In reply please quote: 18/02368
Your Ref: SSI-9186

FAIRFIELD COUNCIL OBJECTION TO THE CABRAMATTA LOOP FREIGHT LINE PROPOSAL

Reference is made to your letter dated 30 August 2019, requesting comments on the Cabramatta Loop Environmental Impact Statement (EIS), being publicly exhibited between the 30 August 2019 and the 26 September 2019. Council objects to the proposal in its current form for the reasons outlined in the body of this letter. This objection follows previous correspondence dated 30 April 2018, 7 May 2018 and 18 July 2019 (**Attachment A**) from Council which included Council's stakeholder input into the Secretary General's Environmental Assessment Requirements (SEAR's) requirements and a response on the consistency of the draft Environmental Impact Statement (EIS) with Department of Planning Industry and Environment issued SEAR's.

Figure 6.6 Existing configuration (top) and indicative proposed revised reconfiguration of Broomfield Street (bottom) (facing south)

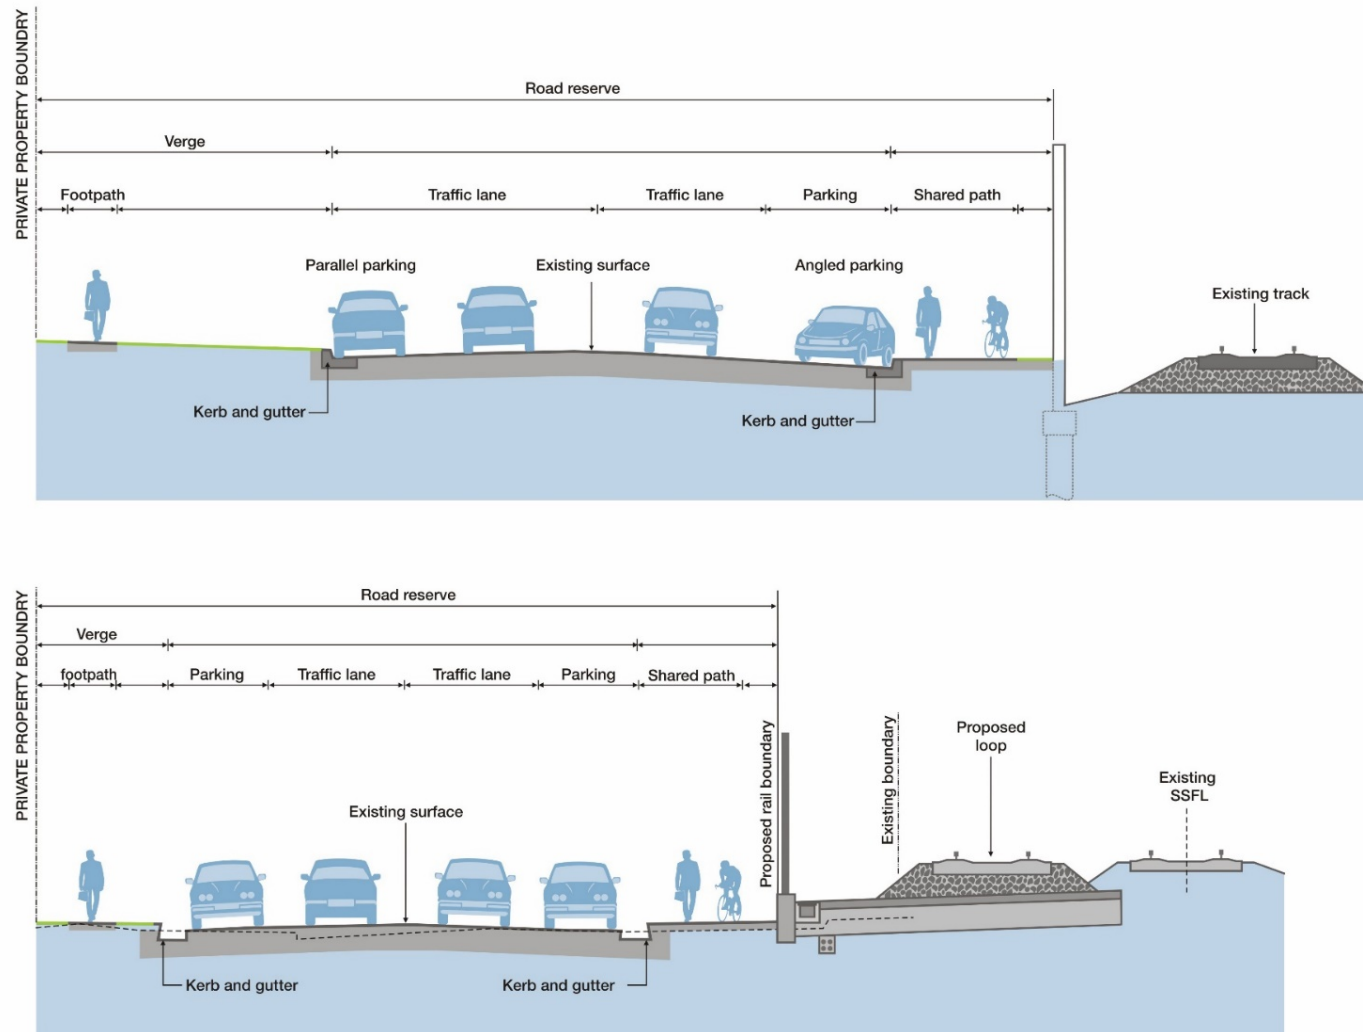
Net Loss of Parking to Broomfield Street - Council met with Australian Rail Track Corporation (ARTC) on the 5 August 2019 for a briefing on the update of the Draft EIS project. In this meeting ARTC's project manager verbally confirmed that there would be no offset parking solution. The 45-degree angle parking to the east of Broomfield Street would be moved to the western side of Broomfield Street and be made into kerb side parking. This will make way for the movement of the sound wall 4 metres westwards. In moving and straightening up the 45-degree angle parking to kerb side parallel parking a net loss of 11 spots will occur. No compensation or offset has been suggested to replace this parking.

The proposed kerb side parking to the western side of Broomfield Street would be placed at the kerb side to the front of existing low density residential dwellings. This is less than ideal as these homes are currently zoned R3 Medium Density Residential and have significant redevelopment potential for multi-unit housing in the future, including townhouse and villa style development.

Redevelopment of these sites for medium density purposes will require provision of a 7 metre access handle under the controls of the Fairfield City Wide DCP 2013. This will impact the solution provided by ARTC and result in a further reduction of parking along Broomfield Street.

Verge shared pathway – The proposed typical cross section of Broomfield Street at chainage CH77 shows a 2.5 metre shared pathway without a verge adjacent to the on-street parallel parking lane. A verge must be provided between the shared pathway and parallel parking lane. A verge is very important for the safety of cyclists and pedestrians as it creates a buffer between cyclists and opening of car doors which are a major cause of collisions between cars and bicycles.

Risk assessment – A risk assessment needs to be undertaken to ensure that the proposed 2.5 metre shared pathway won't compromise safety of pedestrians and/or motorists.

Relocation of parking to Broomfield Street – The project is to result in **no net loss of parking spaces**. Any removal of public parking space will need to be reinstated within 400 metres of the railway station to the satisfaction of Council.
